Location: 98 Ribchester Road and land adj 94 Ribchester Road Clayton-Le-Dale BB1 9HQ
Proposal: Approval of details reserved by conditions 4 (Construction Management Plan), 5 (site access and off-site works), 9 (SW drainage), 12 (drainage scheme) and 14 (landscaping) of planning application 3/2024/0302.

APPLICATION NO. 3/2024/0996

DECISION DATE: 8 August 2025

EXISTING DRAINAGE

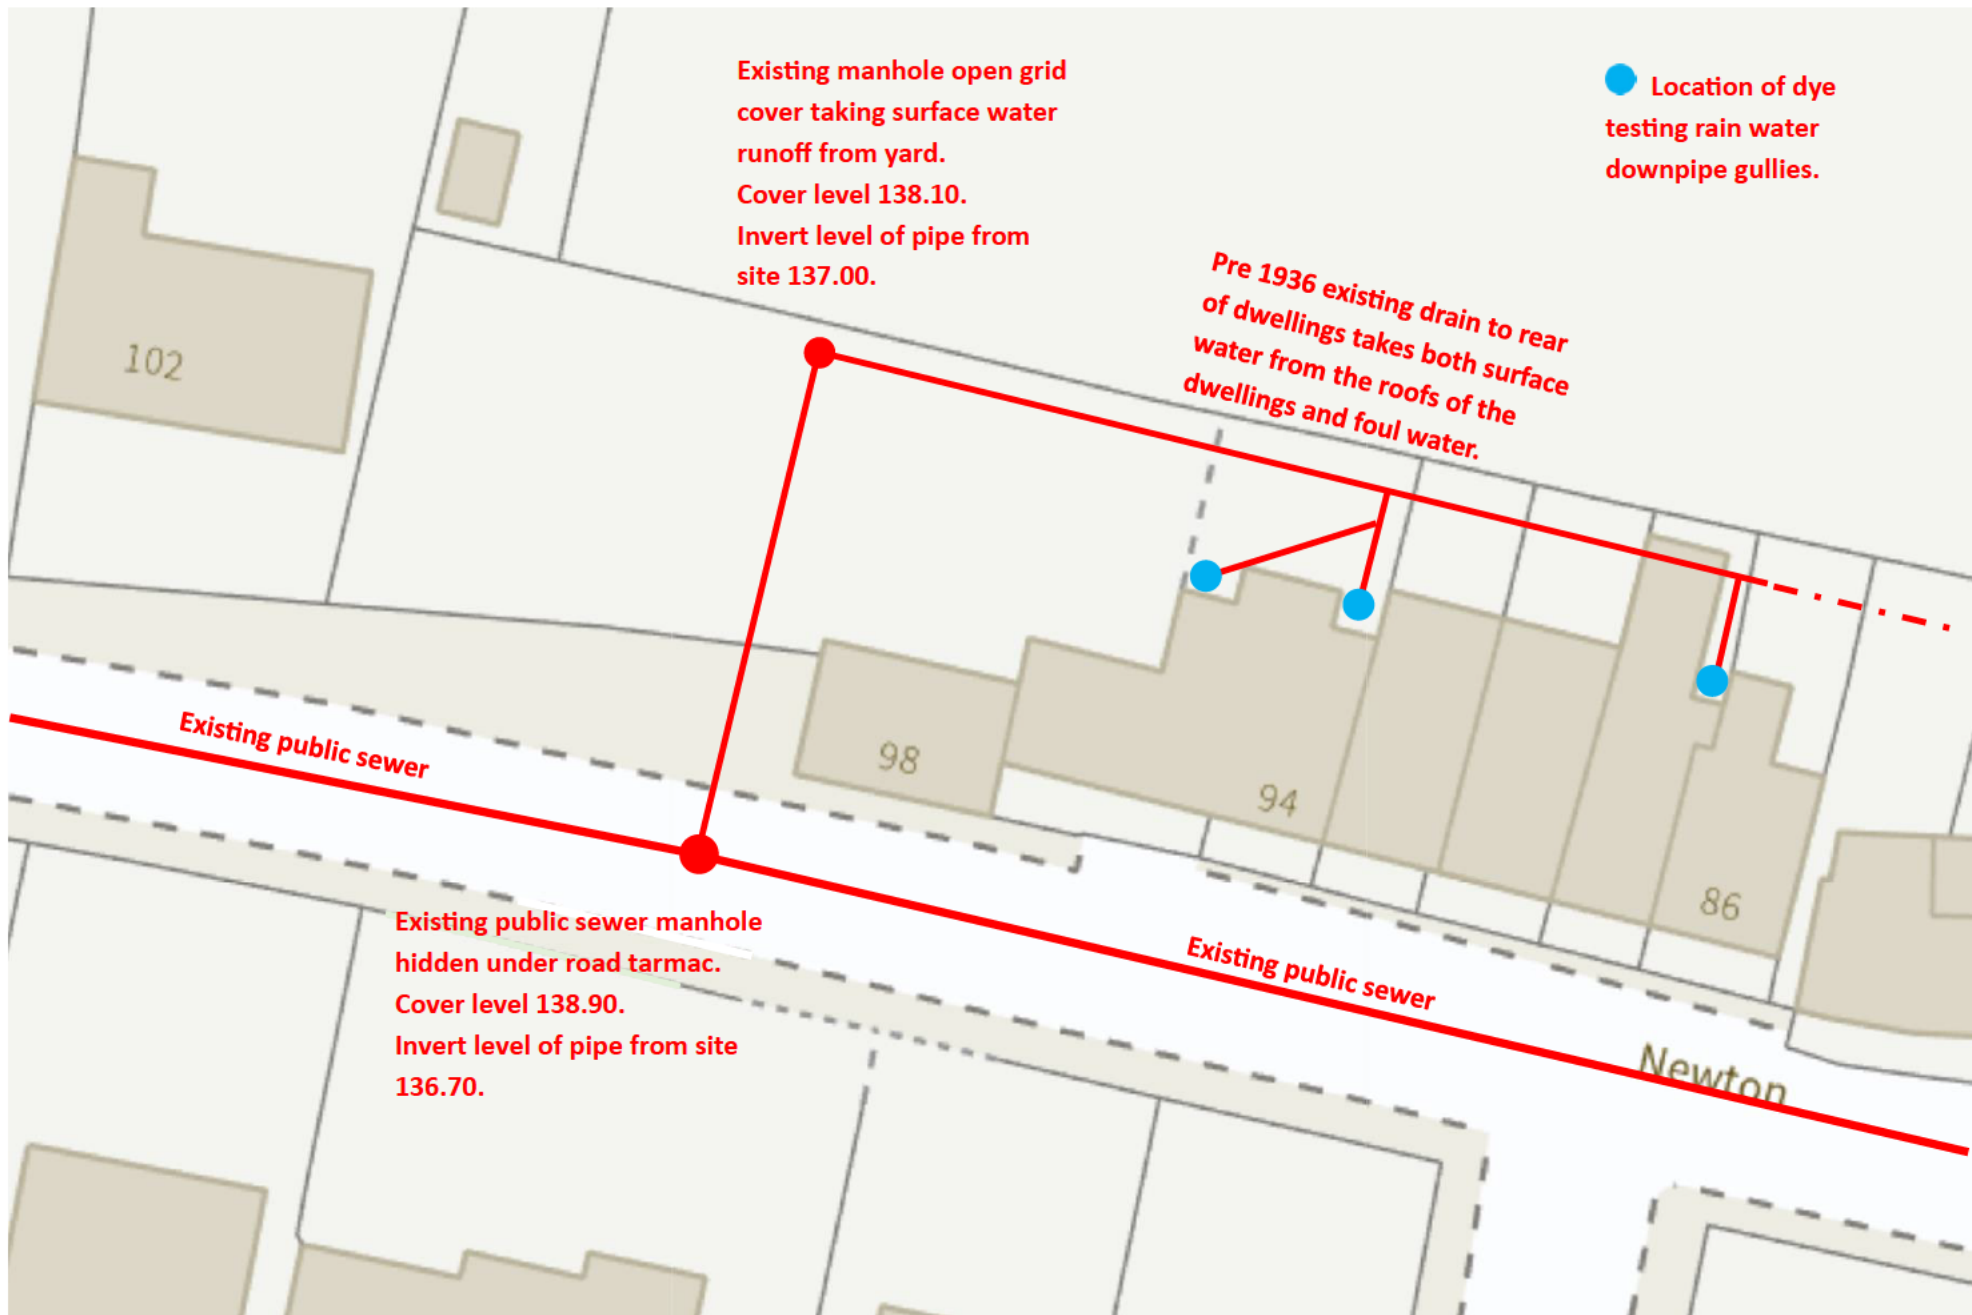
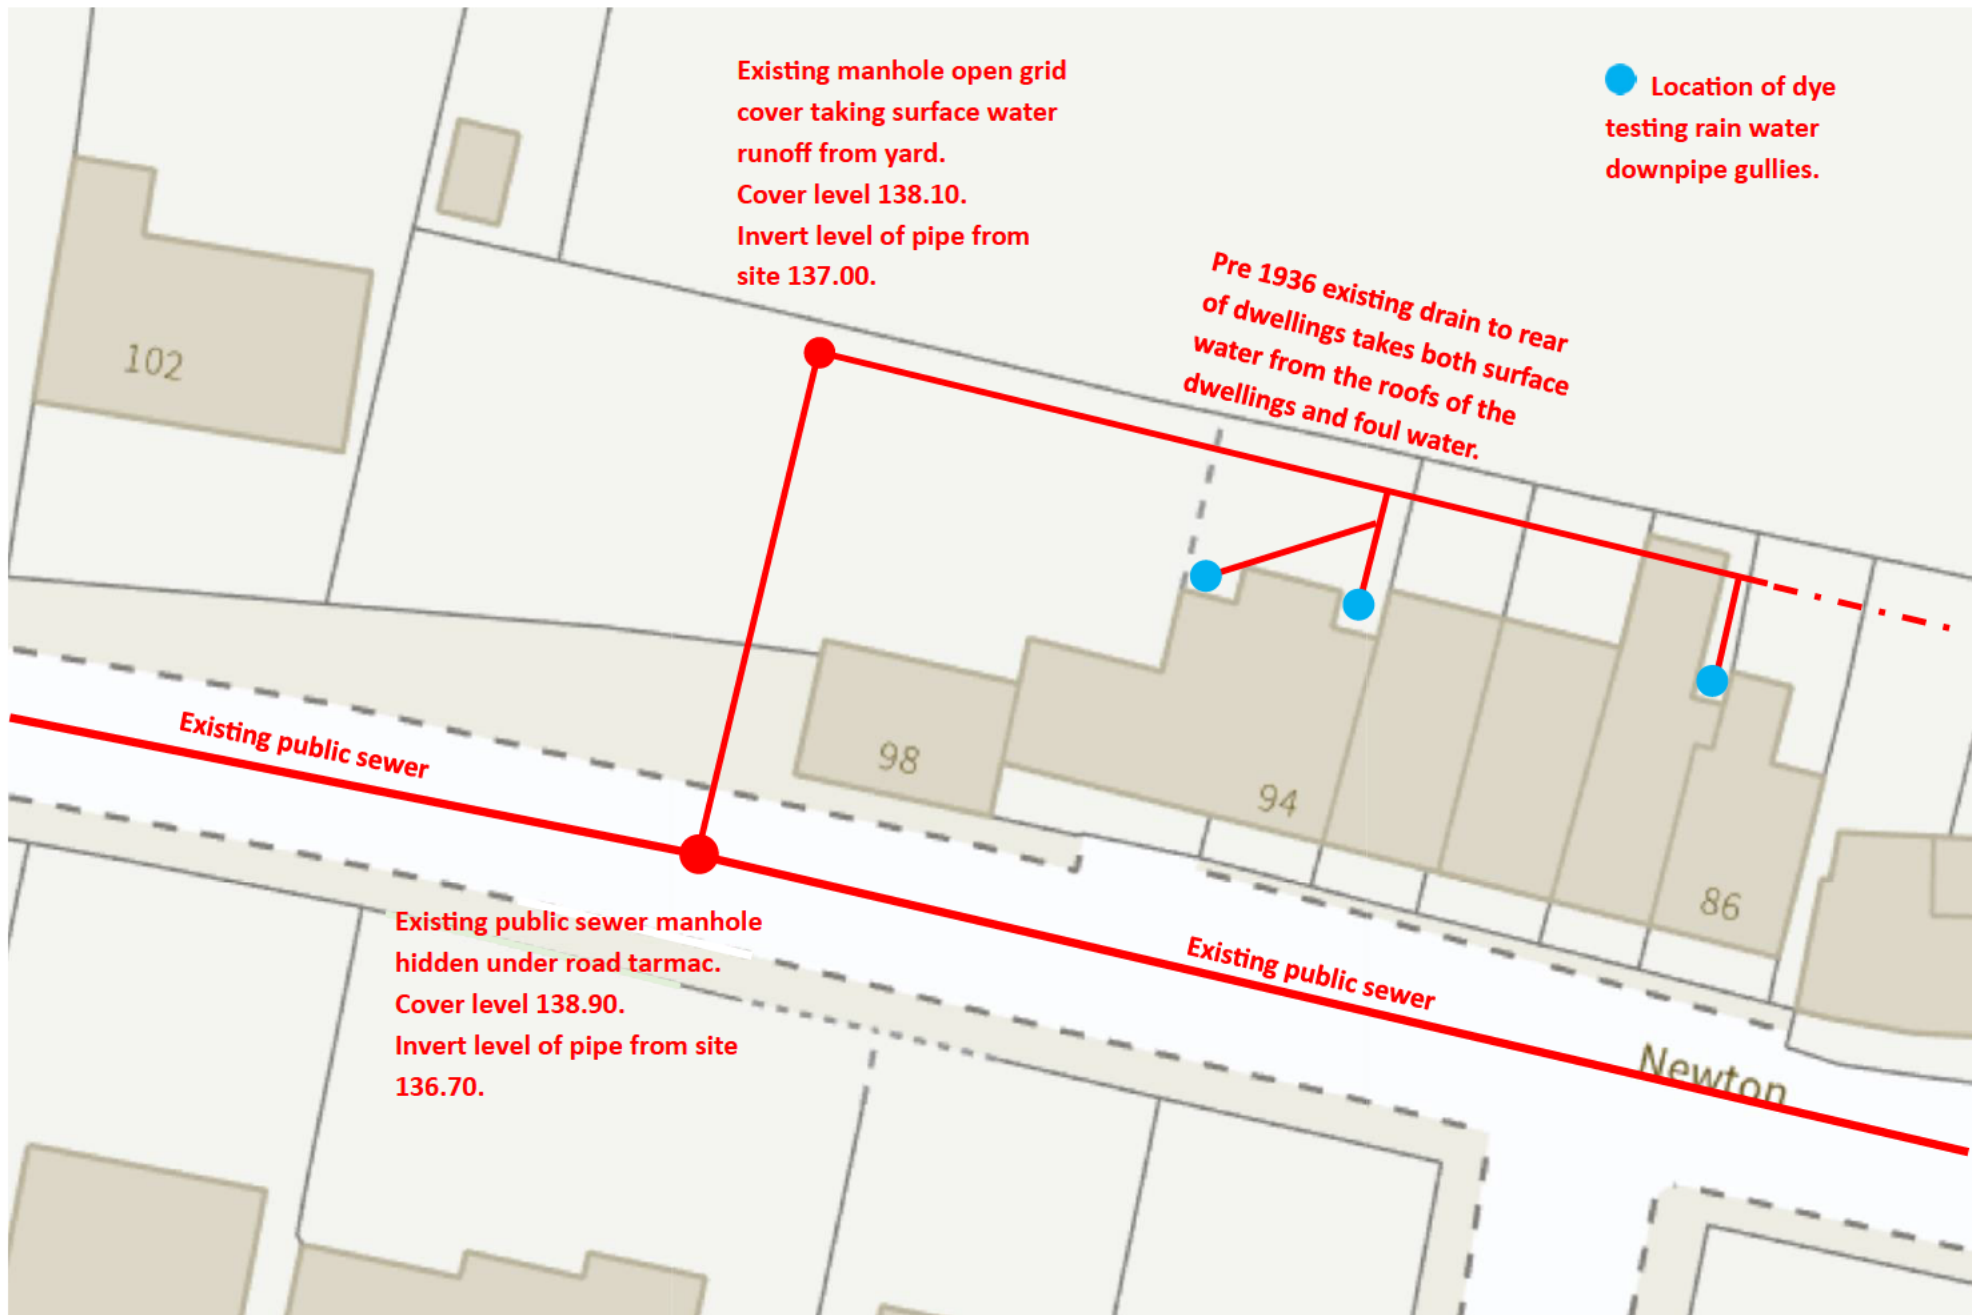
Condition 12 (Drainage scheme) cannot be discharged as insufficient details have been provided in terms of the drainage scheme with regards to the connection with the public wastewater network and a drainage survey to confirm that the foul sewer is a public combined sewer.

23474-DR-C-0800

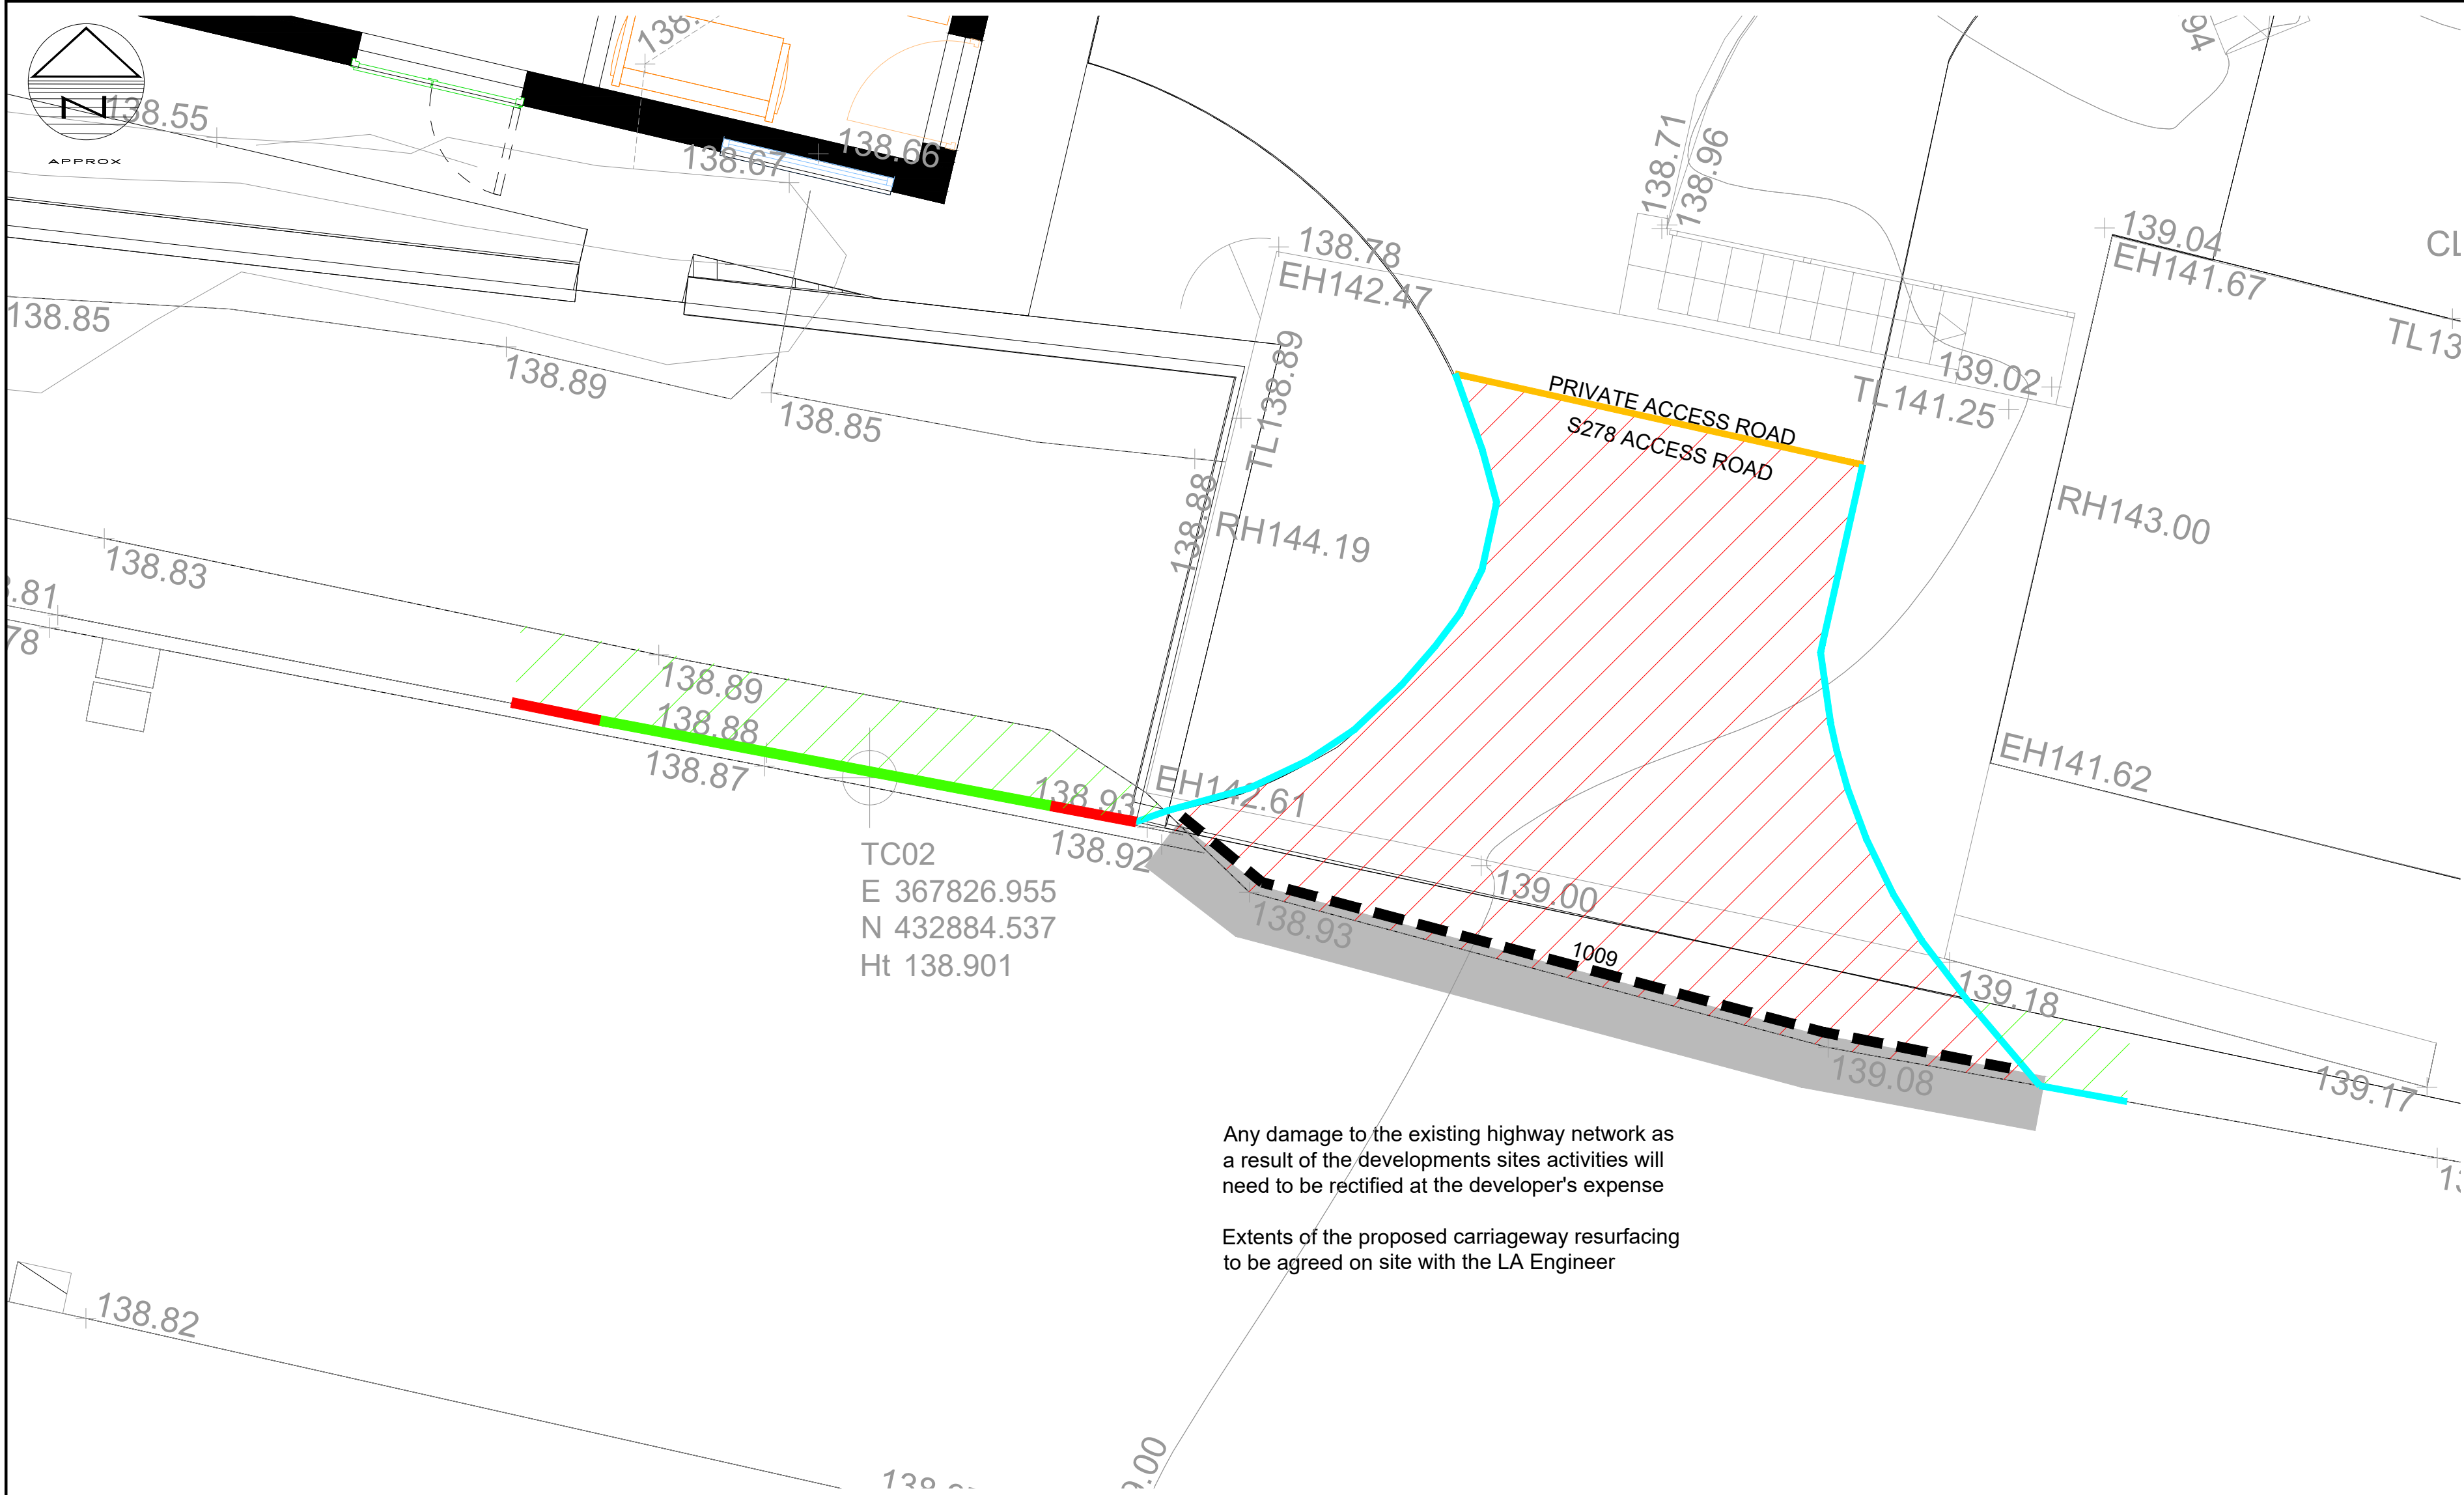
Condition 5 (Site Access and off-site works) can be partially discharged in so far as the details submitted on plan 23474-DR-C-0802 P1 Section 278 Visibility Splays submitted 5th December 2024, plan 23474-DR-C-0800 P3 Section 278 Works submitted 5th December 2024 and plan 23474-DR-C-0801 P2 Section 278 Land Plan are acceptable.
